CITY OF ALBUQUERQUE

December 12, 2019

RE: 1310 Cuesta Arriba Court NE
Grading and Drainage Plan
Engineer's Stamp Date: 12/05/19
Hydrology File: D16D103

GRADING AND DRAINAGE PLAN

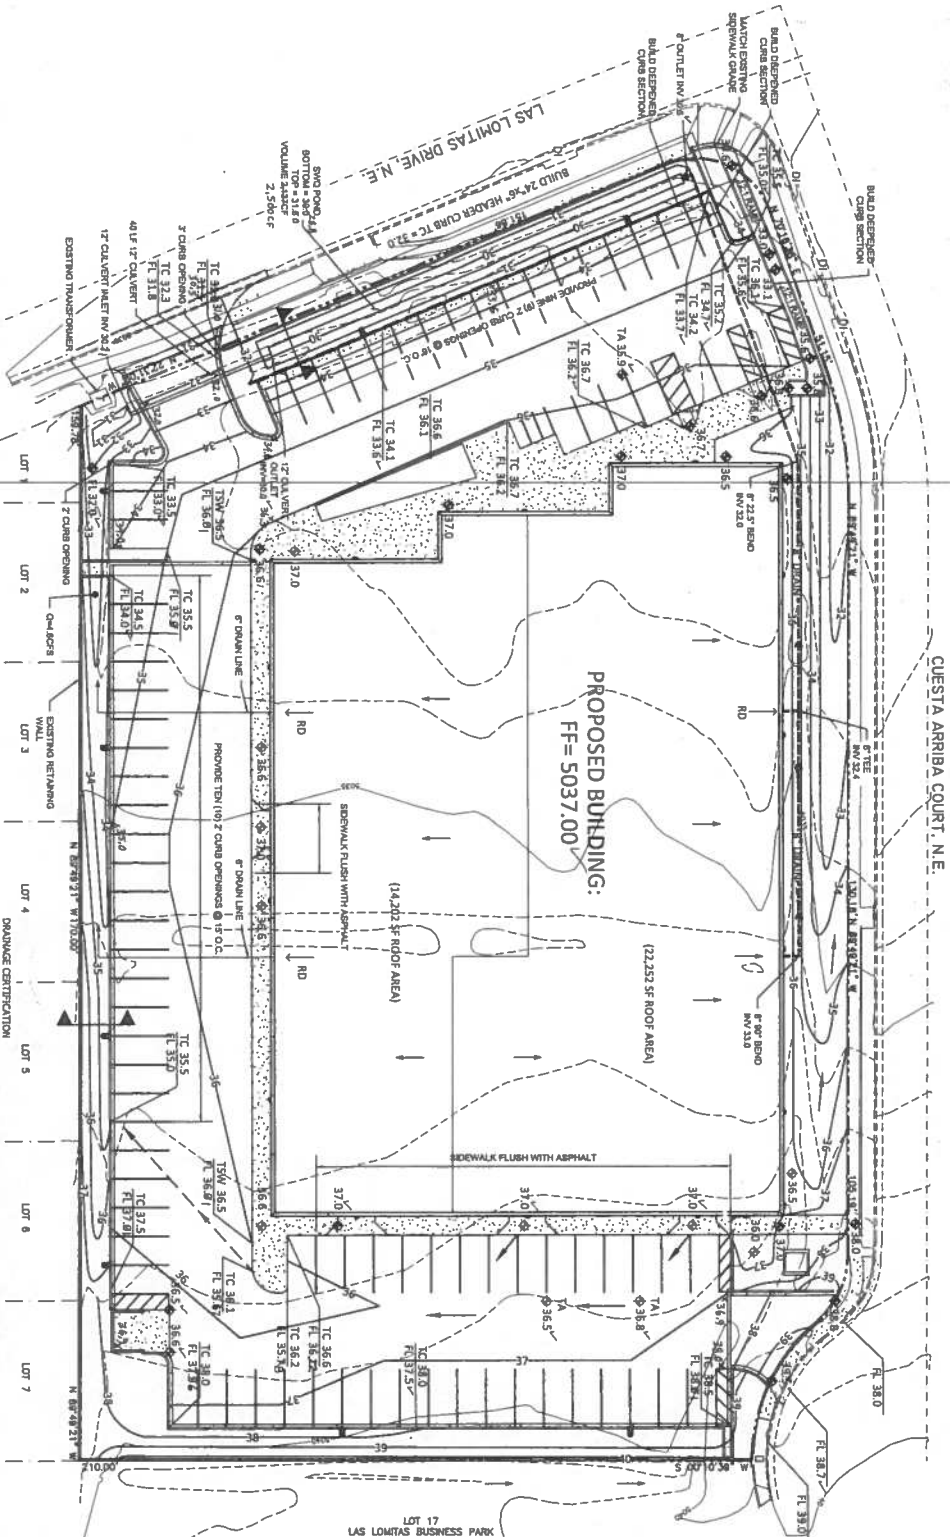
1. There is an existing electrical transformer which is not shown in the southwest corner of the tract. The proposed stormwater quality pond will have to be adjusted. See photo below.

2. There is no existing sidewalk along Cuesta Arriba Court. You show this as existing. Please show the proposed required frontage sidewalk. See photo below.

3. Please provide adjacent property information. This is missing.
4. Please correct both driveways. They are not tied into the existing curb with the proper commercial radius.

5. Please show the on-site curbing. It is hard to tell what is curb and what is flush with the sidewalk.
6. Please correct some of the proposed contours. They are not being tied into the existing contours.

7. Please provide a detail of the non-typical deepened curb.
8. Please change all reference of First Flush to Stormwater Quality. This is the current terminology.

9. Please label the Stormwater Quality Ponds with the provided volume.
10. Please provide an emergency spillway for the Stormwater Quality Pond. Typically this is a 2 feet sidewalk culvert. Also please label this per CoA detail 2236 and include both the inflow and outflow at the gutter.

11. Please check all callouts. Most are unreadable because of the line work that they are over.
12. Please label the existing retaining wall along the southern property line. See photo in comment #1.

13. Please provide a cross-section for this existing retaining wall through the proposed swale and the proposed parking.

14. Please add the Stormwater Quality Volume WSE in the Pond Section.
15. Please provide the weir calculations, per DPM Chapter 22.3.A.1, for the curb cuts and sidewalk culverts. A coefficient of 2.7 is typically used for the weir equation $Q = CLH^{2/3}$.
16. There appears to be an area along Cuesta Arriba Court which does not go into a Stormwater Quality Pond and instead point discharges into the street. Please see if a small pond is needed for this drainage.
17. Standard review fee of \$150 will be required at the time of resubmittal.
